A46 Newark Bypass

Scheme Number: TR010065

Statement of Common Ground with Historic England

**Statement Of Common Ground with
Historic England**

- NOTES**
- THIS DRAWING IS TO BE READ IN CONJUNCTION WITH THE DRAFT DEVELOPMENT CONSENT ORDER AND ACCOMPANYING APPLICATION DOCUMENTATION. (TR010065/APP/3.1).

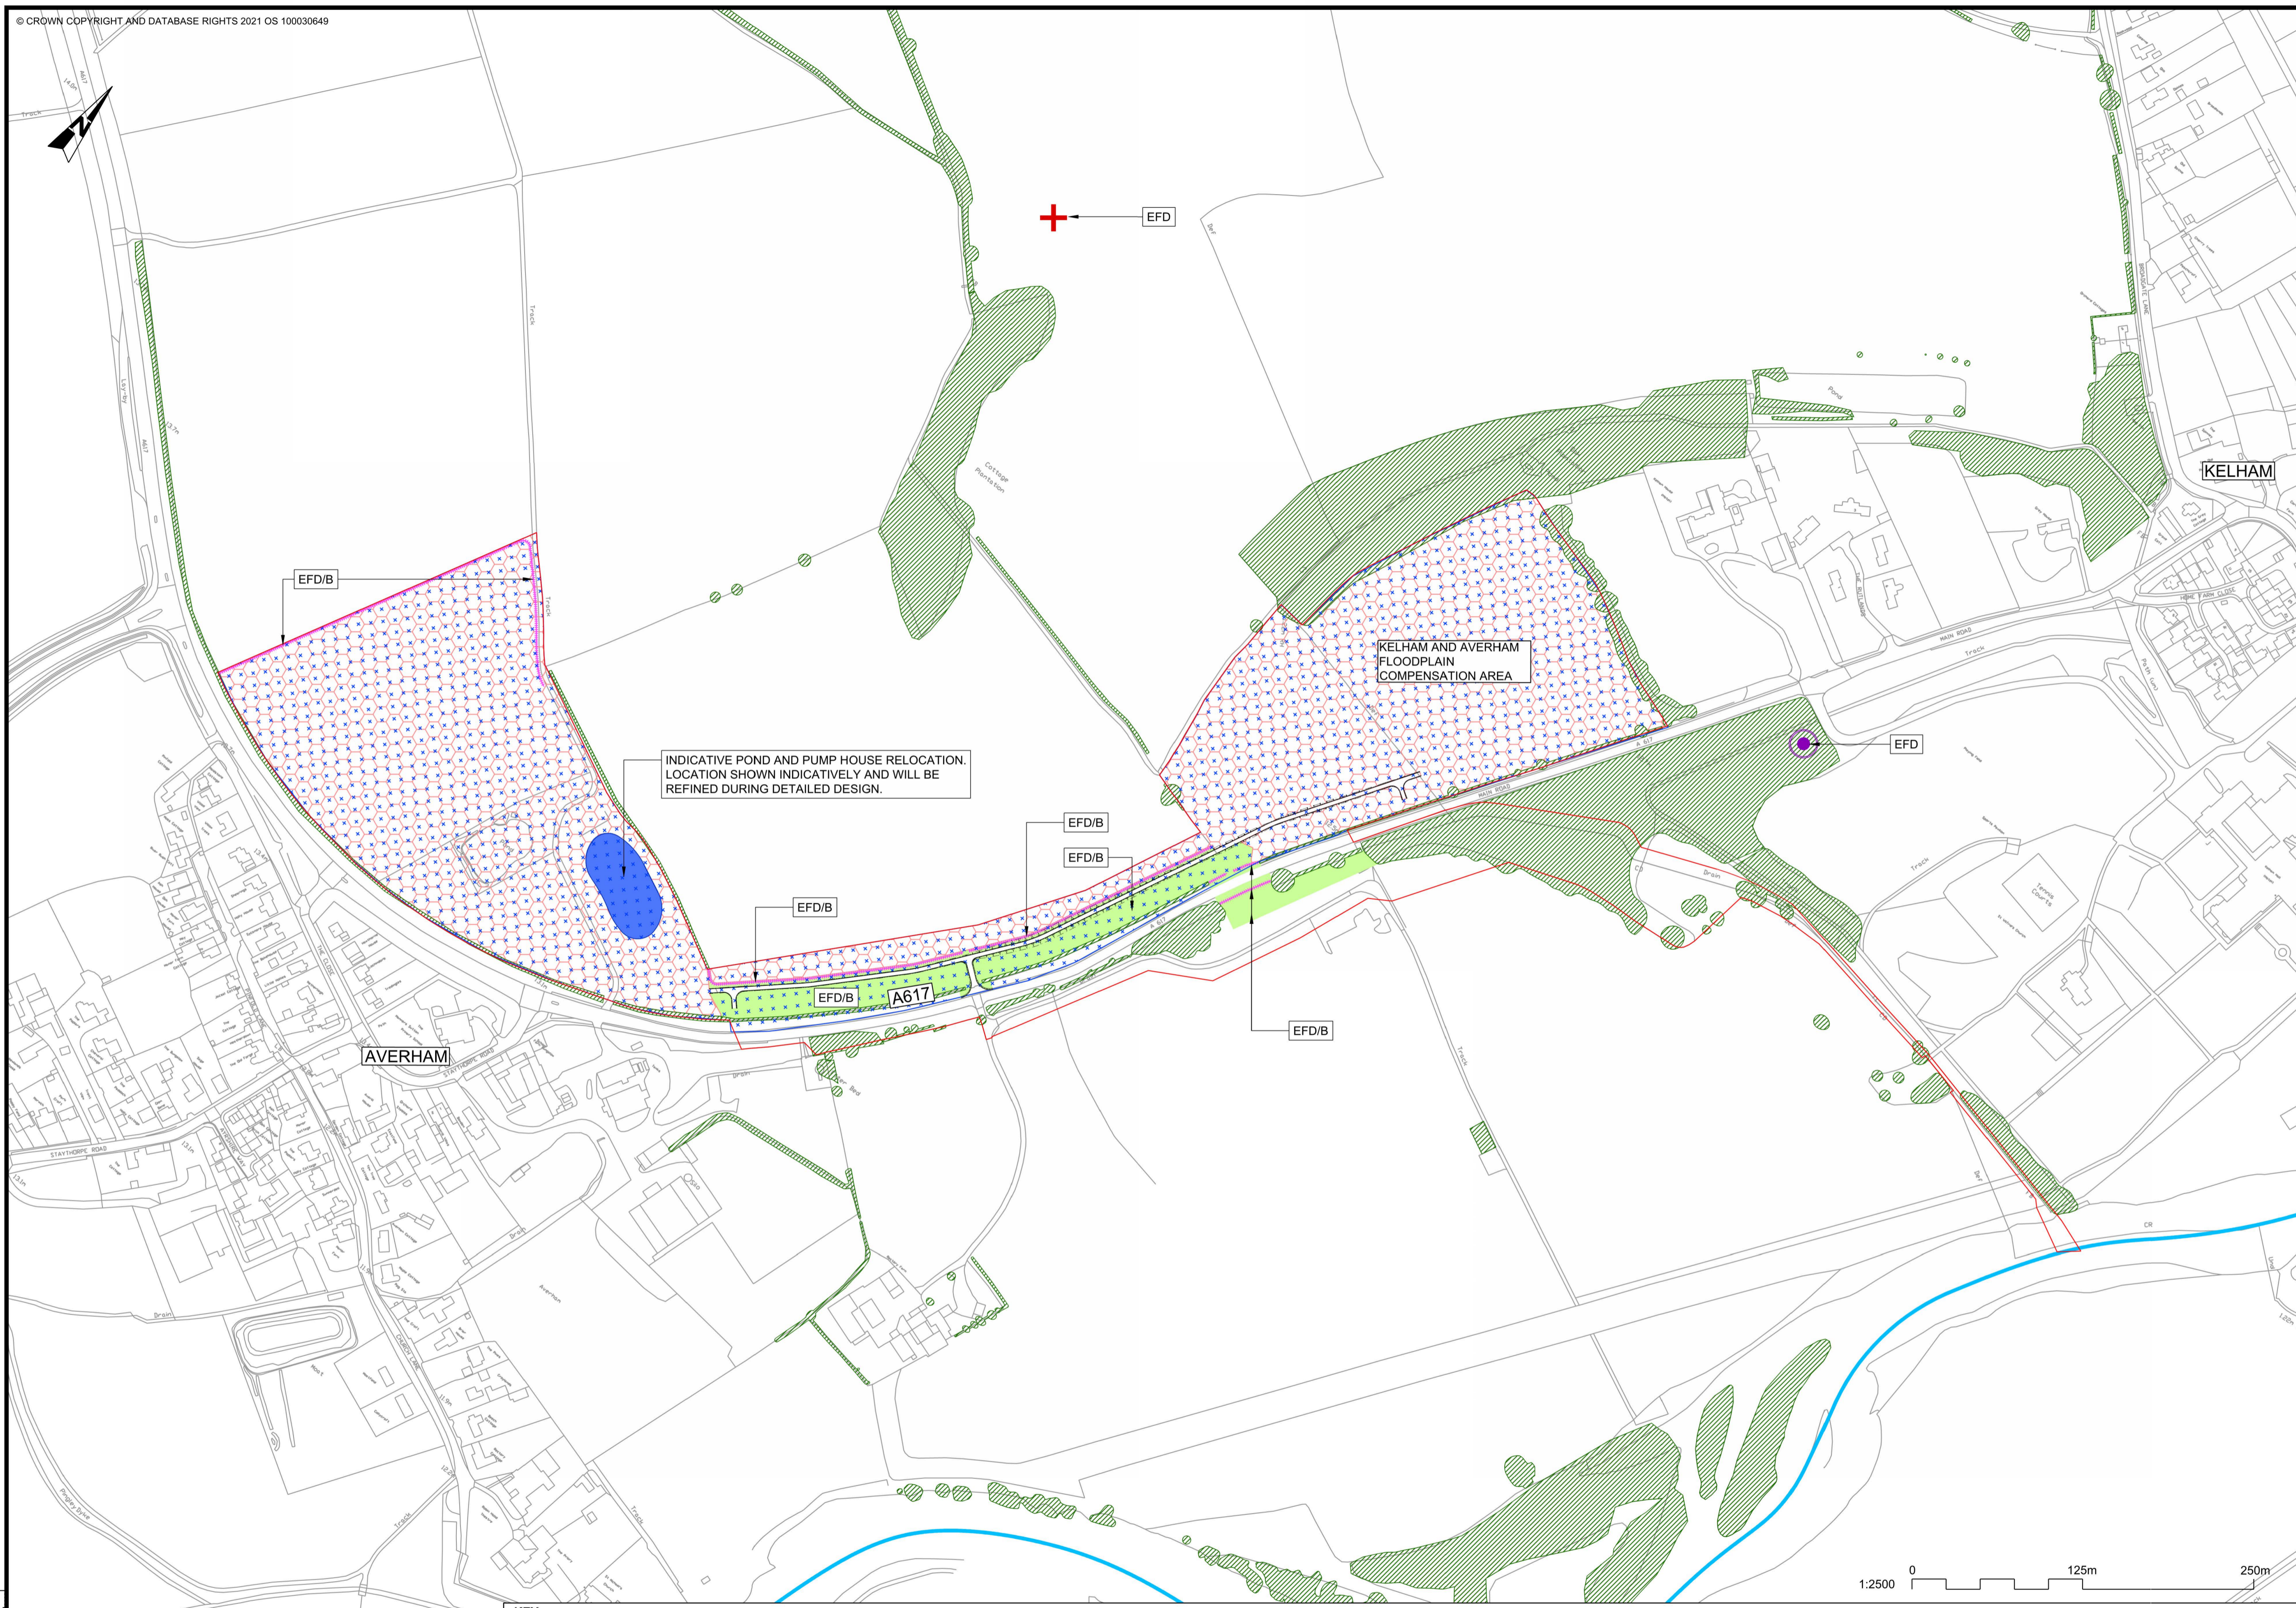
13.	Langford Hall – new approach road and entrance gates	Figure 2.3 (Environmental Masterplan) of the Environmental Statement Figures [AS-026]	<p>Meeting with Historic England 11/10/2024:</p> <p>Understand rationale behind linear route for new driveway between new proposed entrance and location where it meets the existing driveway. This route avoids historic copse of trees at original end of the driveway. The direct line approach meets the existing driveway at a natural break in the trees.</p> <p>Agree that there is no clear rationale, or extra benefit to creating a faux curvilinear approach in this location.</p> <p>Agree that meeting the existing driveway at the proposed location, ensures that the gradual 'reveal' of the main house is retained and conserved.</p> <p>Discussed requirement for new entrance to 'speak to' the architecture of the Langford Hall, and to serve its purpose of ensuring visitors and passers-by that this an entrance to an important property.</p> <p>Also discussed the importance of the design of any gates, piers, railings, to be a 'foretaste' of the architectural style of</p>	<p>Routes to the north of the proposed landscape bund in order to join at location of lodge were considered but had no clear rationale and would result in impacts to habitats through destruction of a historic copse of trees.</p> <p>Proposed linear route from existing field gate, directly to natural break in historic tree-line is a clear choice, and ensures sense of reveal and arrival afforded by existing driveway is retained and maintained.</p> <p>Proposed new driveway will have avenue tree planting, in line with existing parkland/estate entrance characteristics, as outlined in Figure 2.3 (Environmental Masterplan) of the Environmental Statement Figures [AS-026].</p> <p>The Applicant agrees with Historic England's position with regards to design and detailing pillars/gates/railings for the entrance.</p>	Agreed	11/10/2024

Issue No	Issue	Document reference	Historic England's Position	Applicant's Position	Status	Date status confirmed
			<p>the main house – not detailed as a pastiche of work elsewhere, but – appropriate in scale, neo-classical proportion and design, of good quality, natural materials, including brick, stone, lime mortar, estate railings etc, matching the pallet of the house to ensure quality of finished design, and its execution by an appropriately skilled specialist (sub) contractor.</p>
